From: Adrian Dowd
Sent: 22 May 2019 13:14
To: Sharon Craig
Subject: FW: Application 3/2019/0091 - Greendale View, Chatburn

**Application 3/2019/0091
Greendale View, Chatburn**

Further to the Borough Council's consultation of 8 April 2019, I would be grateful for your considerations and comments on the proposed holiday let scheme in the AONB (particularly in respect to changes made following the pre-application of April 2018 e.g. log cabins instead of tents).

SHEET:
SITE PLAN

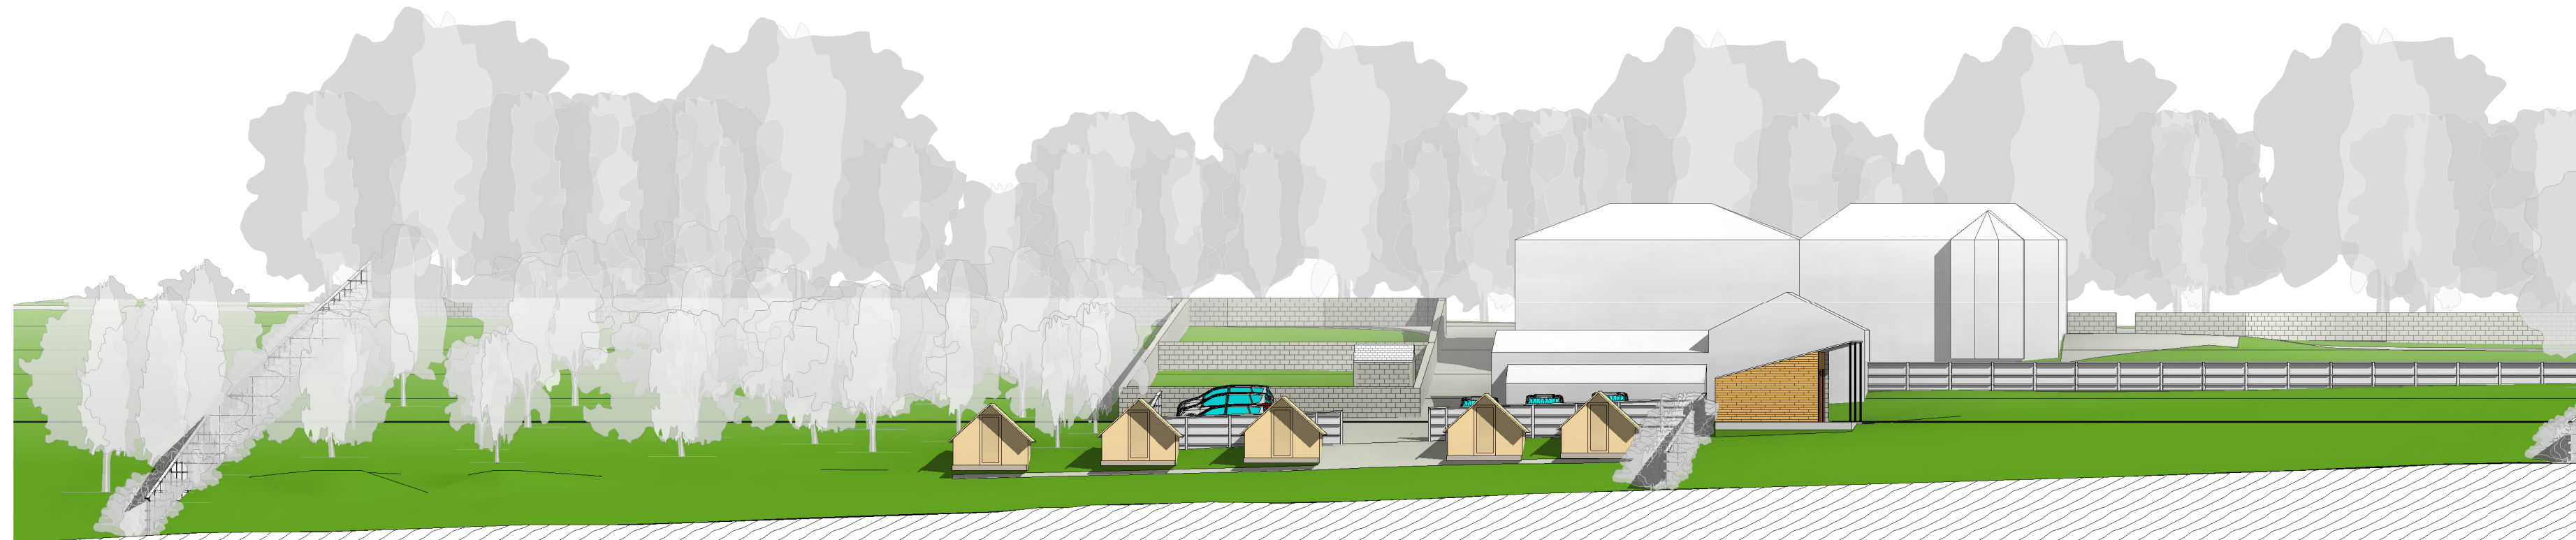
The proposed cabins/pods are sited within a field behind the buildings at Greendale, and it appears they will be largely screened from views from the Chatburn - Downham Road due to the topography and intervening buildings/vegetation.

Views from the north of Greendale (principally from the public right of way just outside the AONB) do not appear to be significant either. The public right of way is 300 – 350m away and with a combination of distance, intervening vegetation and size/low roof height of the cabins, the landscape and visual effects are not likely to be significant.
